WEST SUSSEX COUNTY COUNCIL CONSULTATION

TO:	Arun District Council FAO: Amber Willard
FROM:	WSCC - Highways Authority
DATE:	28 November 2019
LOCATION:	Ground Floor, 6 Ockley Road, Bognor Regis, PO21 2HW
SUBJECT:	BR/191/19/PL Change of use from factory workshop (B1 Business) to tyre fitting shop (Sui Generis).
DATE OF SITE VISIT:	N/A
RECOMMENDATION:	More Information
S106 CONTRIBUTION TOTAL:	N/A

LOCATION PLAN

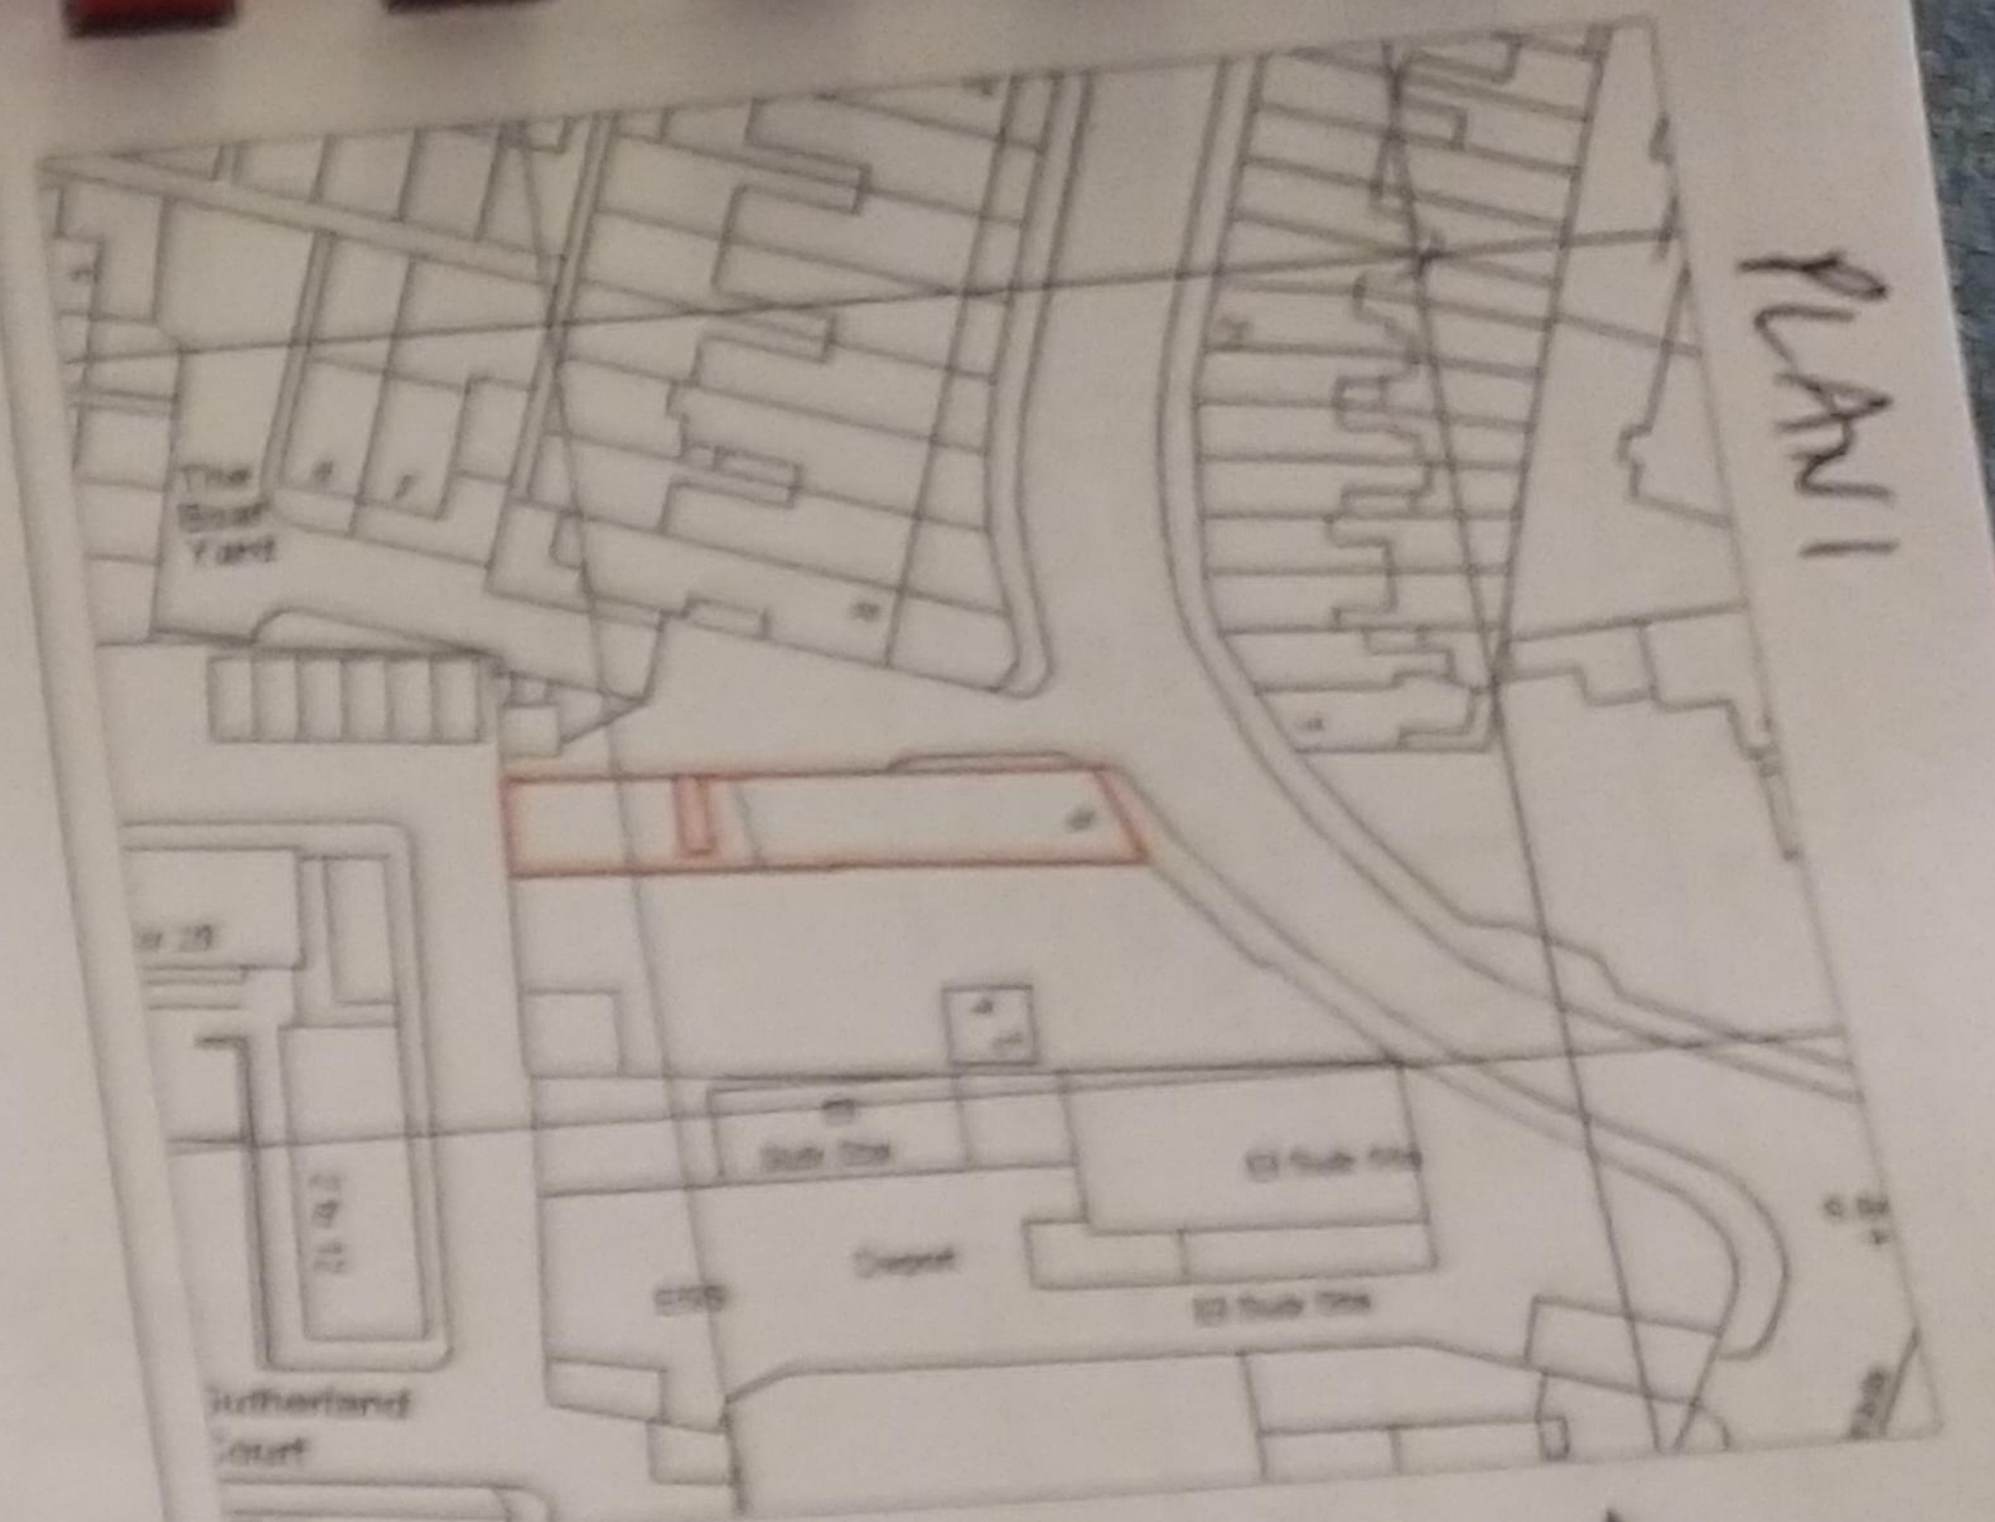
Furthermore, it is unclear from local mapping whether the kerb fronting the site access has been dropped. The LHA requests clarification of whether the kerb fronting the site has been dropped. If the kerb requires dropping, this would be subject to a licence obtained through the local area office. The vehicle crossover (VCO) would be constructed to a specification agreed with the local area engineer.

EXISTING GROUND FLOOR PLAN
SCALE 1:100

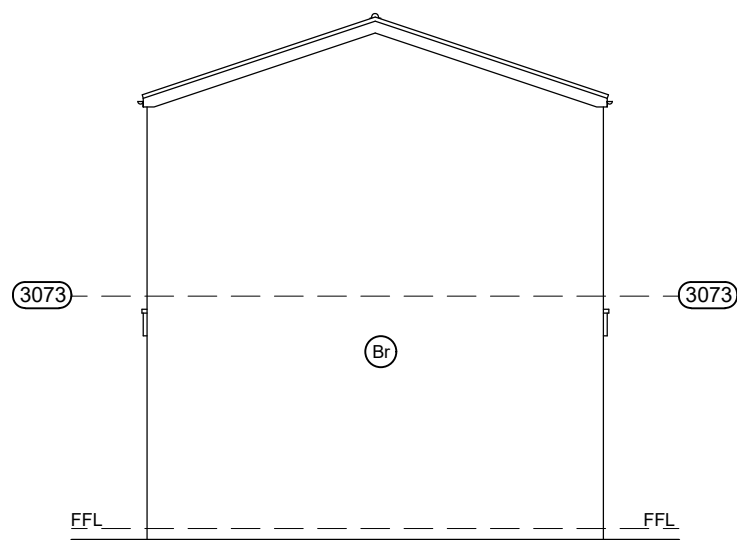
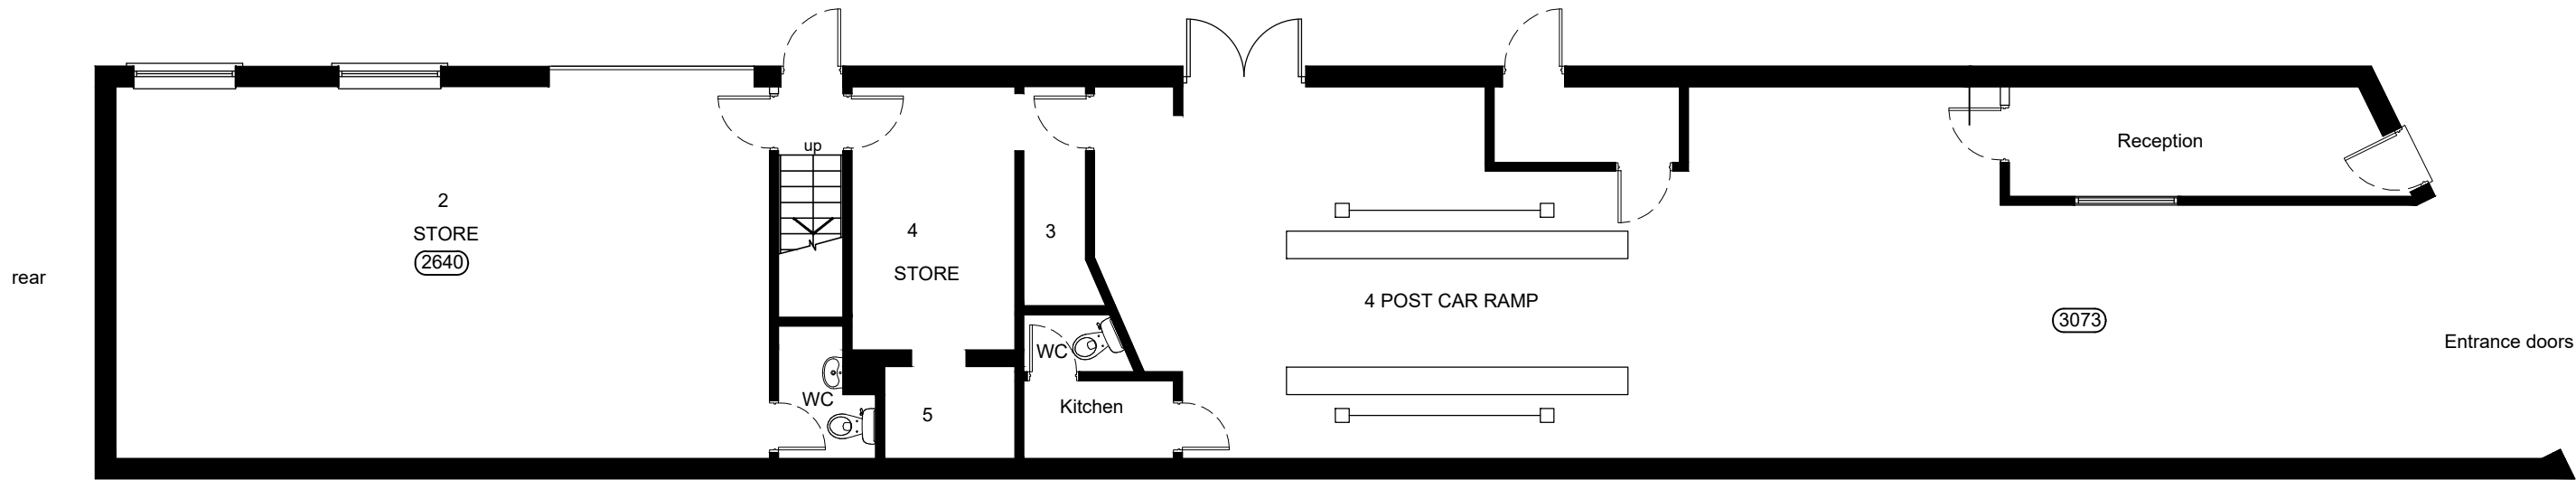
The application form states that 6 car parking spaces are proposed for this development. However, these have not been demonstrated in the plans. The Local Highway Authority (LHA) requests a parking arrangement plan from the applicant, clearly showing the location of all proposed parking spaces.
